From: Sarah Burrow <Sarah.Burrow@arun.gov.uk>
Sent: 21 December 2021 15:31
To: Planning.Responses <Planning.Responses@arun.gov.uk>
Cc: Maria Tomalova <Maria.Tomalova@arun.gov.uk>
Subject: RE: Planning Consultation on: BE/163/21/PL

Engineers Comments Regarding Surface Water Drainage

Application No: BE/163/21/PL

Site Address: 22 Osprey Gardens Bersted PO22 9QG

Ground floor plan
1 : 50

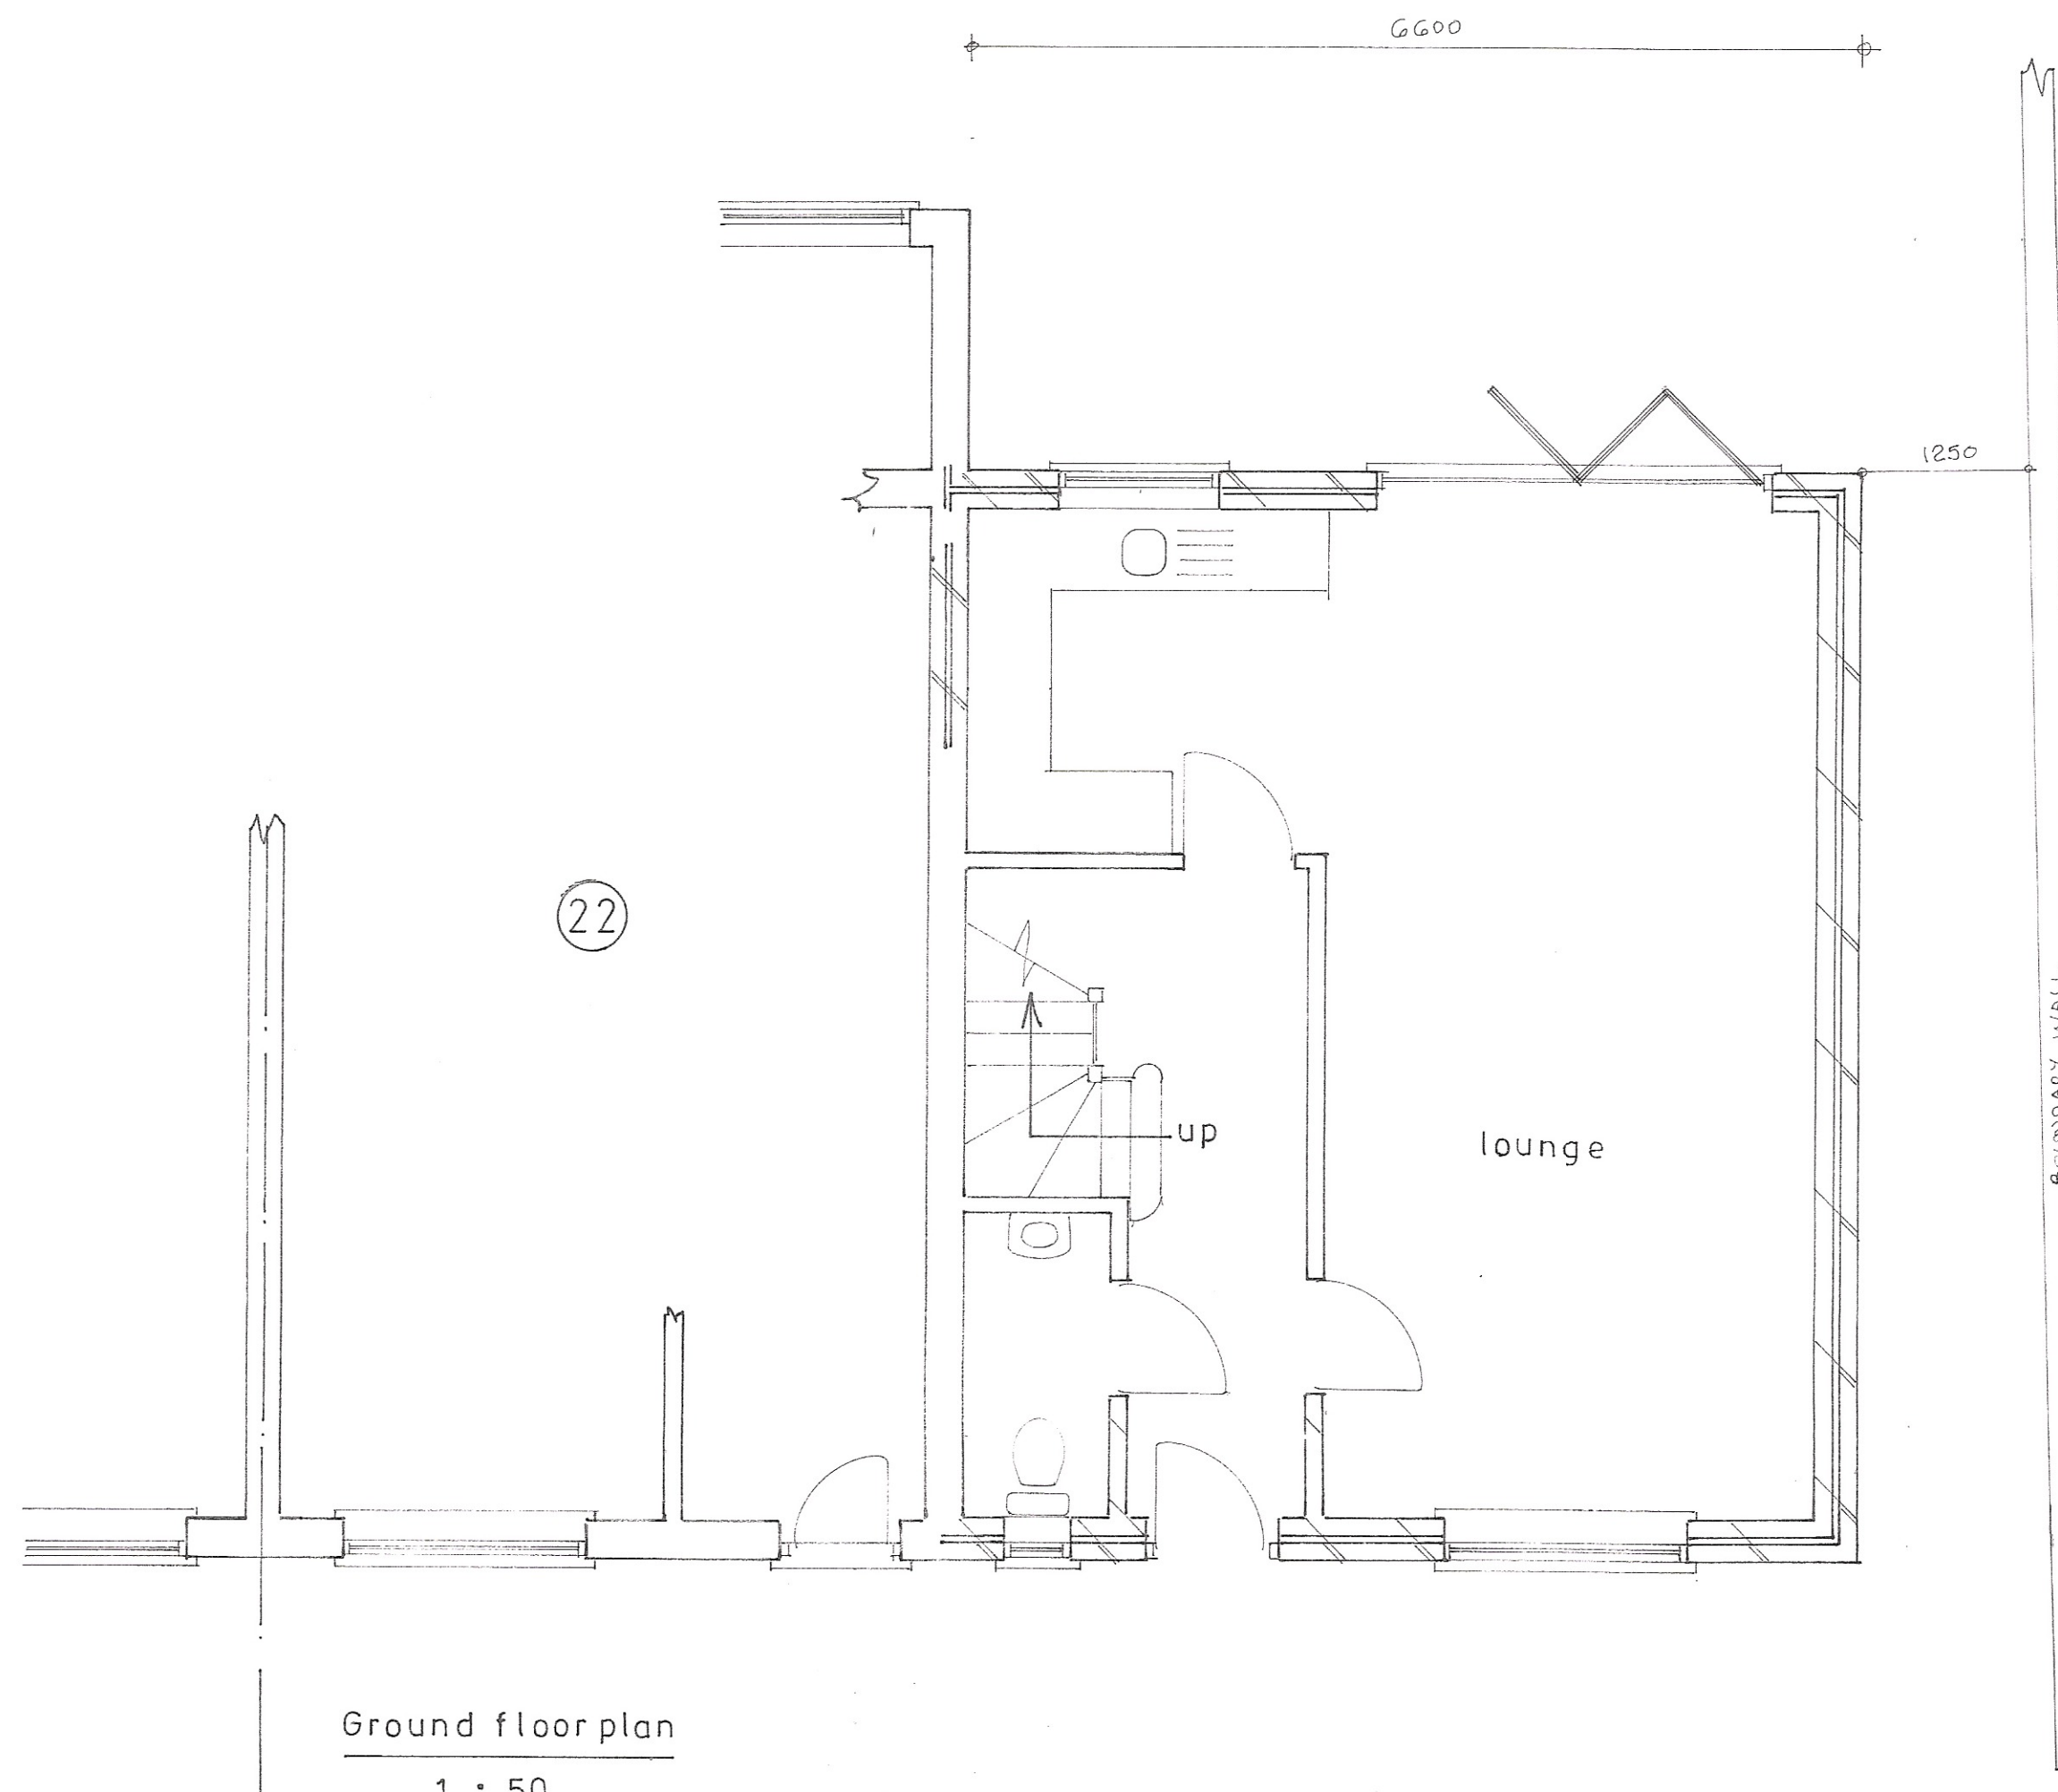
The applicant should be aware that our mapping shows a foul sewer running north-south under the proposed dwelling. Please consult Southern Water for a copy of their records and any necessary easements or build-over agreements.
